**Reference: WW010003 - Cambridge Waste Water Treatment Plant Relocation**

### **Objection – potential impact to veteran trees**

The Trust **objects** to the proposed Waterbeach pipeline route on the basis of potential damage and deterioration of two veteran trees that are identified within the Arboricultural Impact Assessment (APP-104).

DRAWING TITLE	
TREE PROTECTION PLAN	
PROJECT	
CWWTPR - WBRM	
CLIENT	
ANGLIAN WATER @one	
SCALE	1:500
DATE OF ISSUE	FEB 2022
SURVEYOR	GMC DATE
DRAWN BY	GMC
DRAWING No.	TPP_WATERBEACH_9_2 B
No.	DATE
B	07/2022
REVISION	REVISED LAYOUT

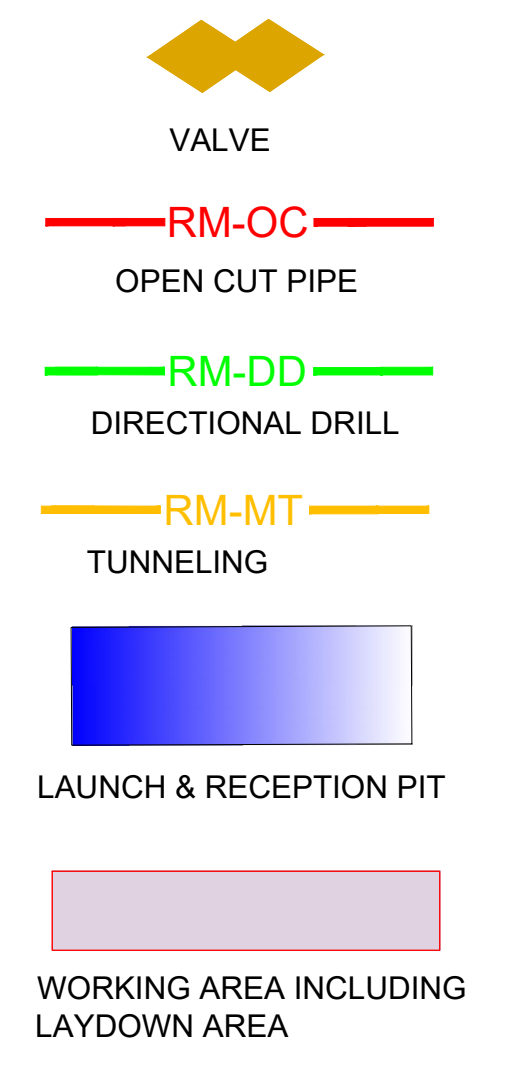
Figure 8.3 (AS-050) outlines the presence of two veteran oak trees within close proximity to the Waterbeach pipeline route, however the accompanying Arboricultural Impact Assessment (APP-104) does not outline any proposed protection measures to address the impacts to these trees. Therefore, we ask that the applicants provide a Tree Constraints/Protection Plan to accompany this proposal.

While BS5837 guidelines state that trees should have a root protection area (RPA) of 12 times the stem diameter (capped at 15m), this guidance does recognise that veteran trees need particular care to ensure adequate space is allowed for their long-term retention. It is imperative that Natural England and Forestry Commission’s standing advice on root protection areas for veteran trees is considered in planning decisions. This advice states: *“For ancient or veteran trees (including those on the woodland boundary), the **buffer zone should be at least 15 times larger than the diameter of the tree. The buffer zone should be 5 metres from the edge of the tree’s canopy if that area is larger than 15 times the tree’s diameter. This will create a minimum root protection area. Where assessment shows other impacts are likely to extend beyond this distance, the proposal is likely to need a larger buffer zone.**”*
